Portishead Branch Line (MetroWest Phase 1)

9.23 ExA.ISH2.D4.V1 – Applicant's Oral Case and response to Representations at the Issue Specific Hearing 2 (ISH2)

Applicant's Oral Case and response to Representations at the Issue Specific Hearing 2 (ISH2) held on 11 January 2021 at 10am

Document Reference: 9.23 ExA.ISH2.D4.V1

2.42 - Pill Station Car Park and PSP Layout, Landscaping Lighting and Access Plan

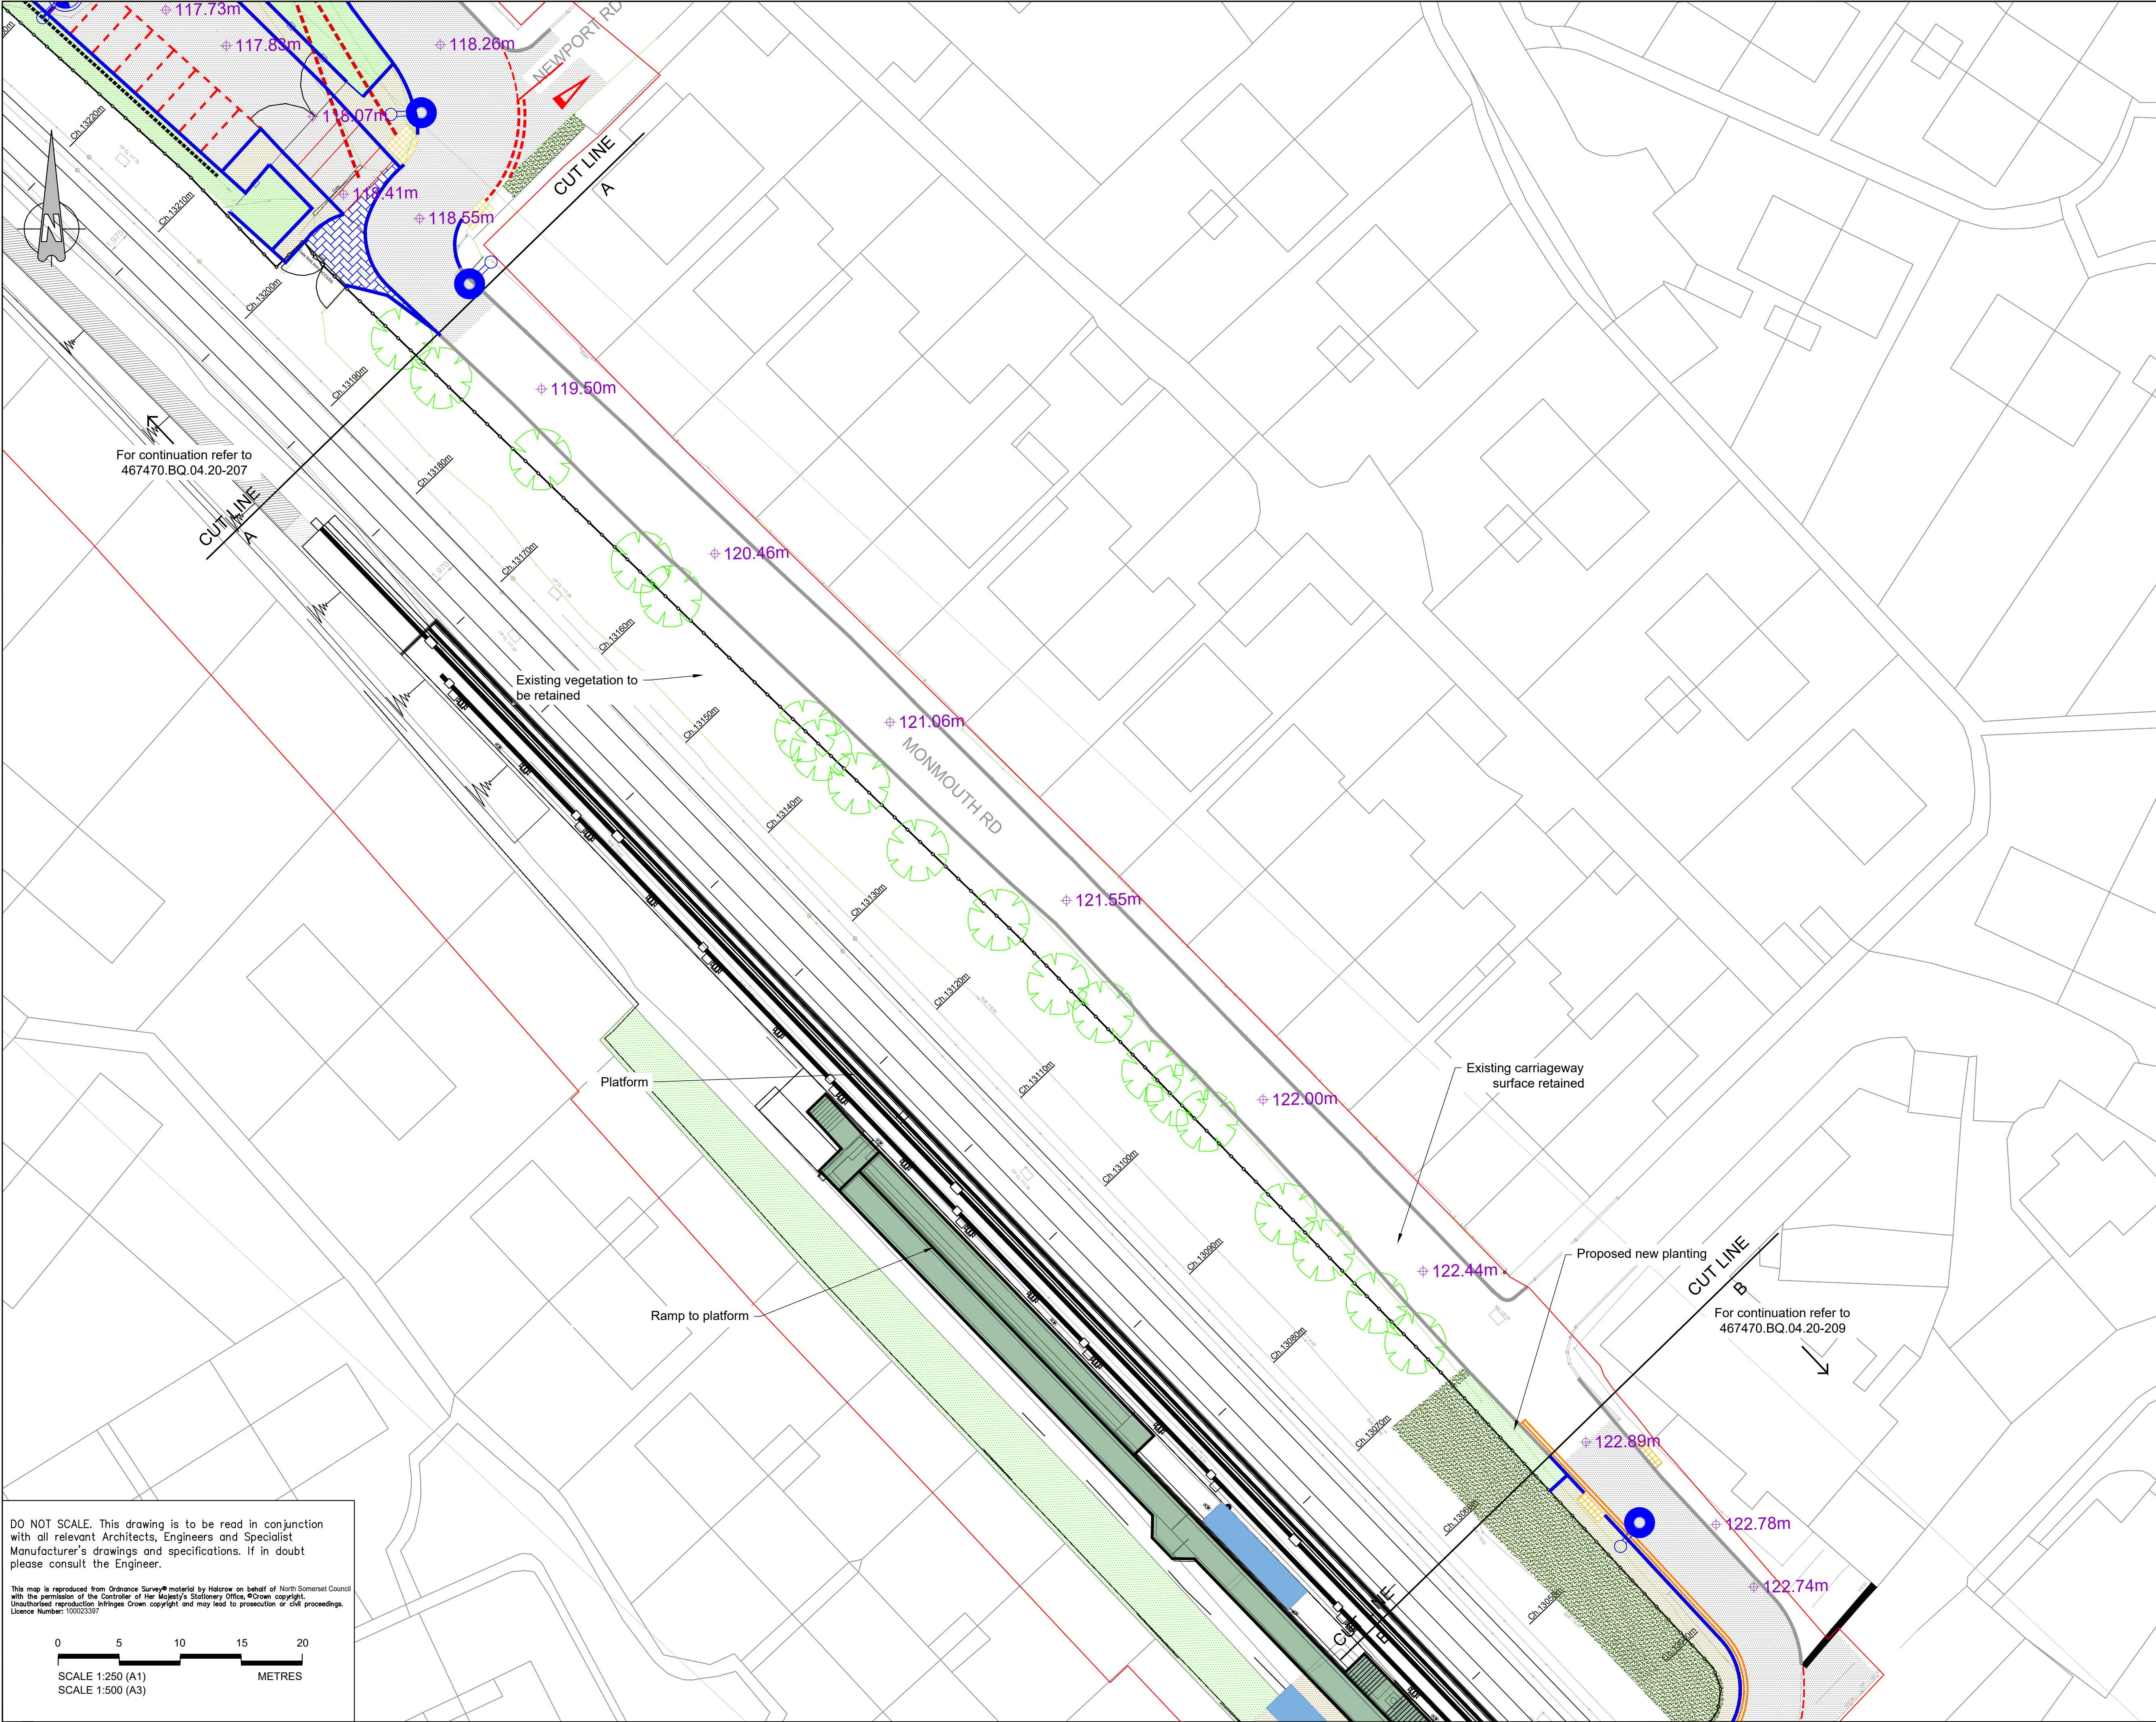
15.	ExA Panel	There are views [of Pill station and car park] from properties on Sambourne Lane, Monmouth Road, and Monmouth Court. Can the Applicant explain how	The Applicant stated that in relation to Severn Road and Monmouth Road, the drawings within the Application documents (Ref: APP-038) show the intention to retain the existing vegetation around the	Please refer to drawing 467470.BQ.04.20-207 within APP-038.

Ref	Comment/ Representation by:	Questions/Issues Raised at the ISH	Applicant's Response at the ISH	Applicant's Written Response
		views from these properties will be mitigated against? If palisade is to be used for the fencing on car park, please confirm the colour of this.	car park. If this is not possible then it will be replanted. In relation to Monmouth Road, the existing bankside vegetation down to the track is being retained and therefore the existing screening features will be retained. Residents in the properties will be able to see the top of the platform. Station Road does change in that Station House is removed. In relation to the houses to the west of the cutting and station, on Sambourne Lane and Hardwicke Road, their existing boundaries and garden fences will remain so there will be no change there. The Applicant believes that the fences will be coloured but will confirm in writing.	There will be a security fence between the main car park and the track along with a vehicle restraint barrier to prevent vehicle incursion onto the track. There would also be security fence around the Network Rail maintenance compound which would be between the compound and the retained hedge adjacent to Severn Road. The car park itself would be gated and fenced. The fence type and detail has not been selected as yet, but does not need to be a high security fence. Fence colours have not yet been specified.
